Application No: 6/2022/2901/HOUSE

Sub: Proposed development at 42 daffodil close, Hatfield, AL10 9FF

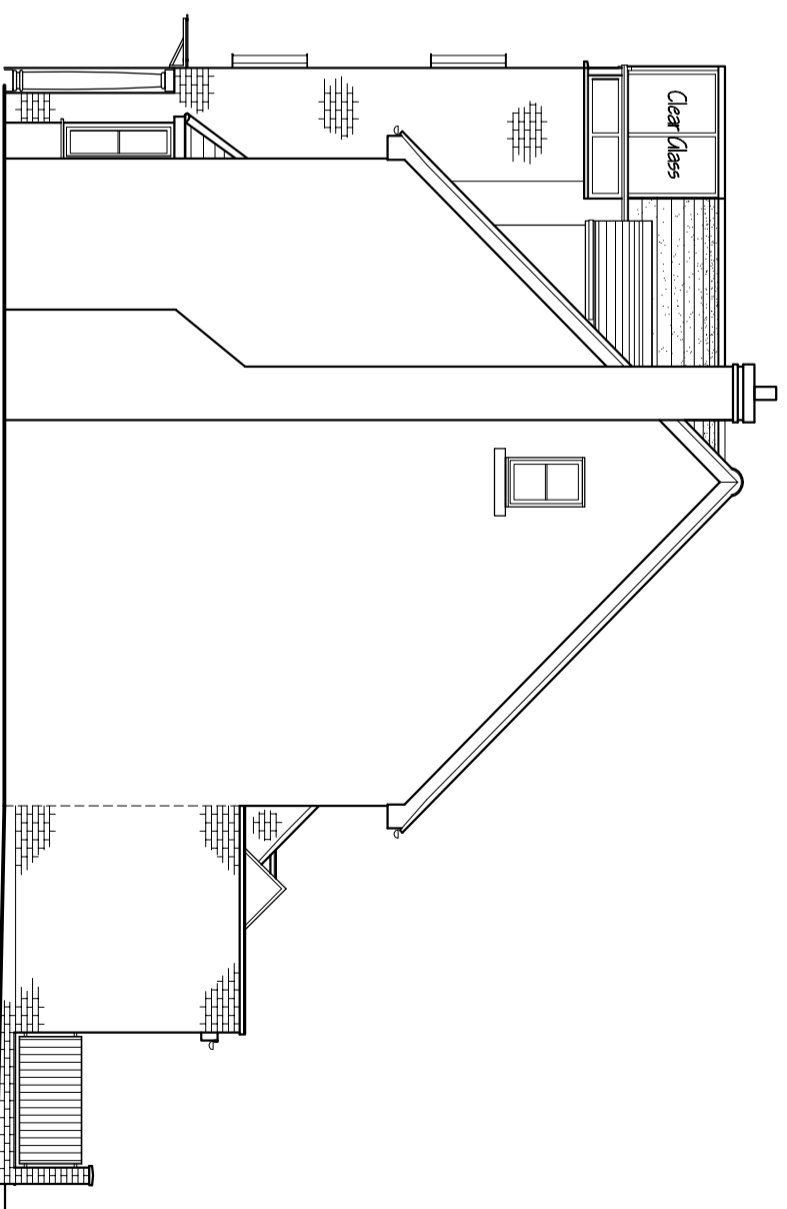
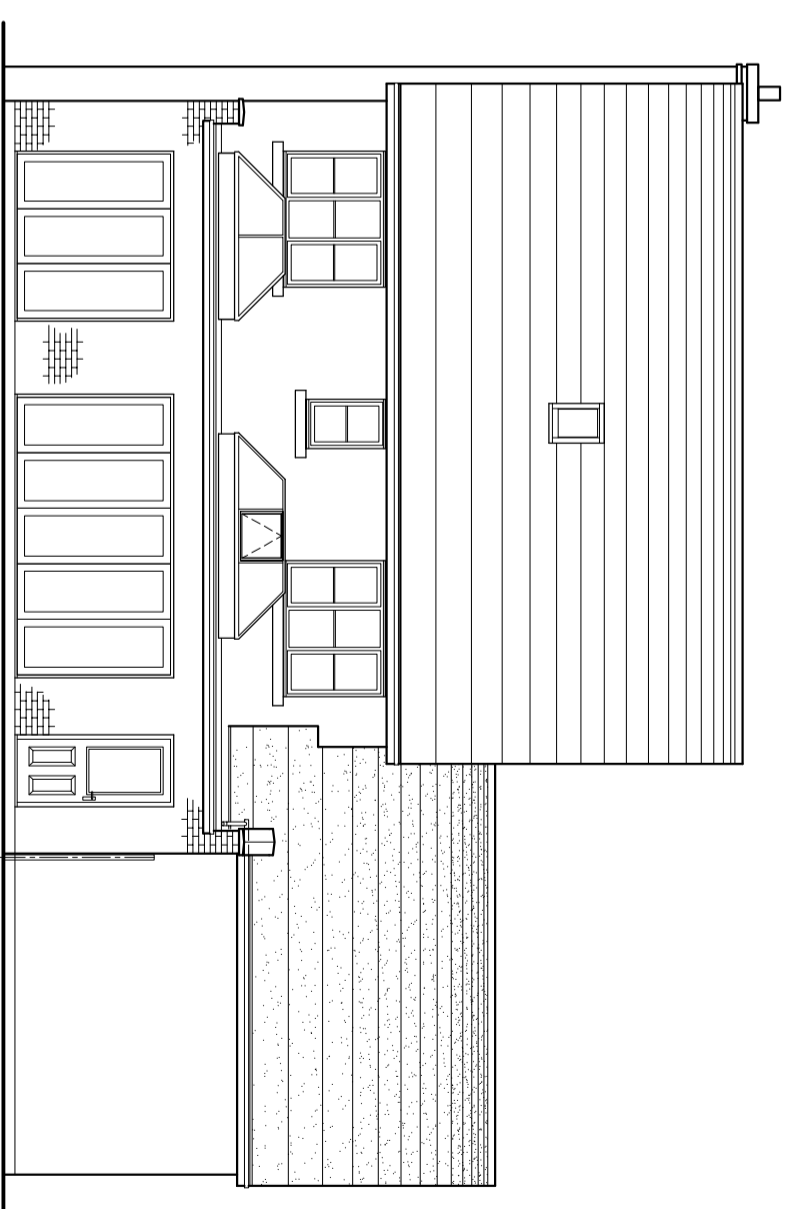
We live at 40 Daffodil close and the side of the 1st floor garage extension and the front dormer windows would disturb our lives and privacy completely. The garage forms part of our perimeter wall and as far as we can see, the only way the proposed extension can be built is for scaffolding to be put on our property. This would be unacceptable. Our back garden is only 10 meters deep from the garage and perimeter wall to our patio and kitchen breakfast room.

The side elevation of no.42 has always dominated our outlook just by the sheer height of the house and it would be much worse with this large 1st floor extension over the double garage. It would cut out even more light and late afternoon sun. This along with the dust, noise and the inconvenience that goes with the building work of this large scale, only 10 yards away from our patio makes us very concerned.

Title PROPOSED FLOOR PLANS - SHEET 3

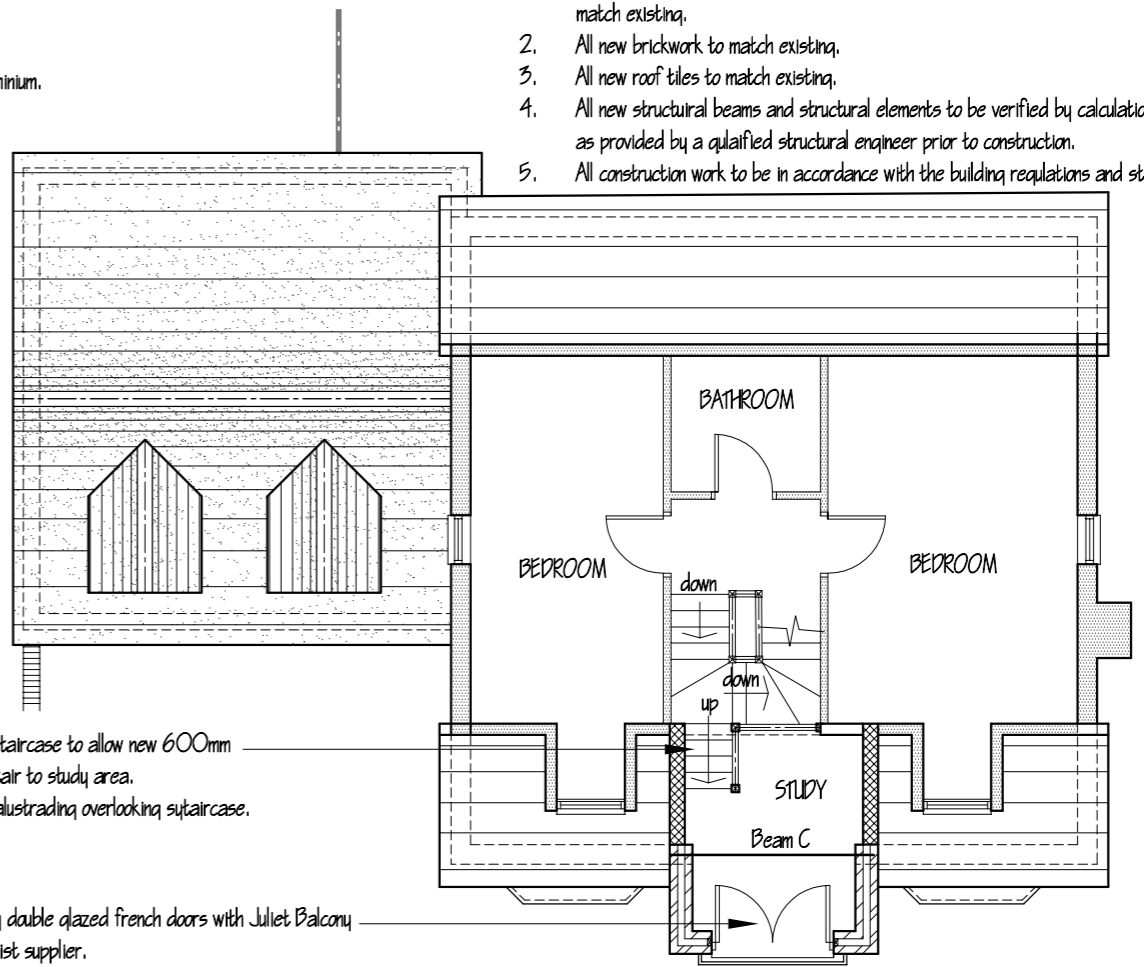
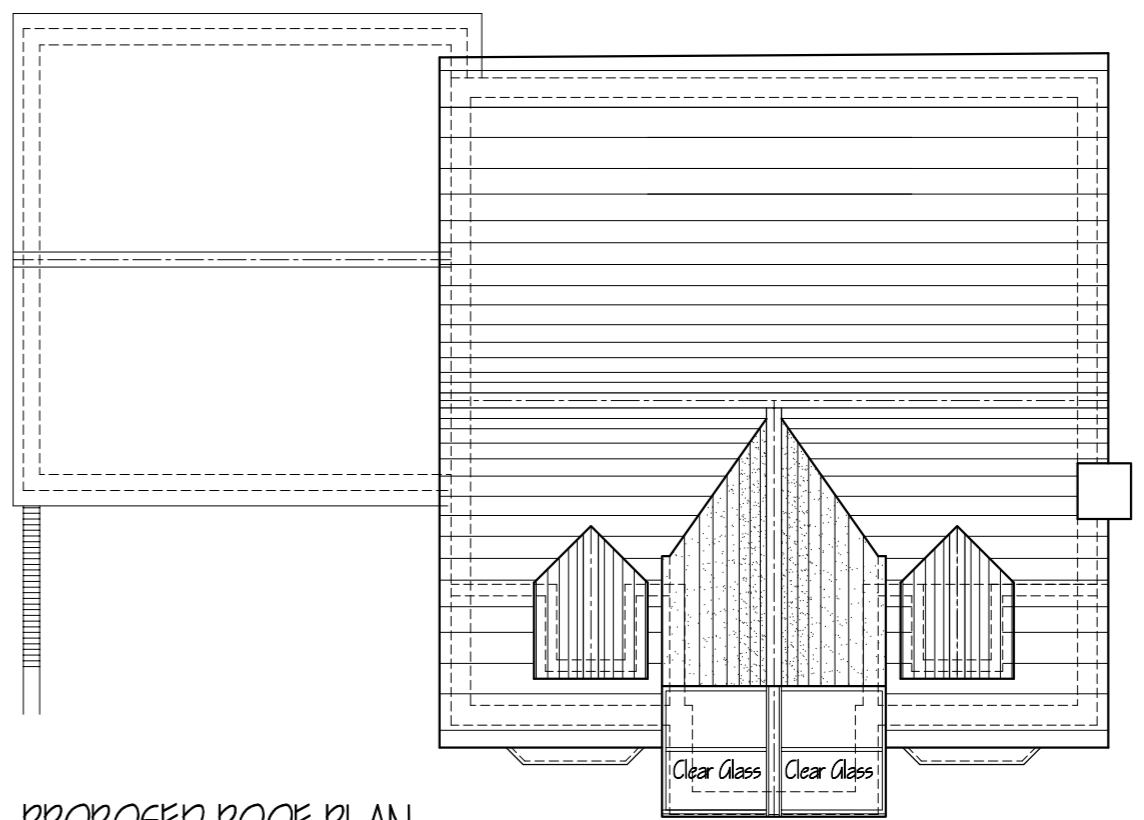
By virtue of the proposal, there is loss of parking space by converting the garage into habitable space. The proposed annex can easily be rented out separately in future and this could further increase loading on off-street parking. No 42 is a large 5 bedroom house and the proposed extensions would make it far too large for the plot of land it occupies.
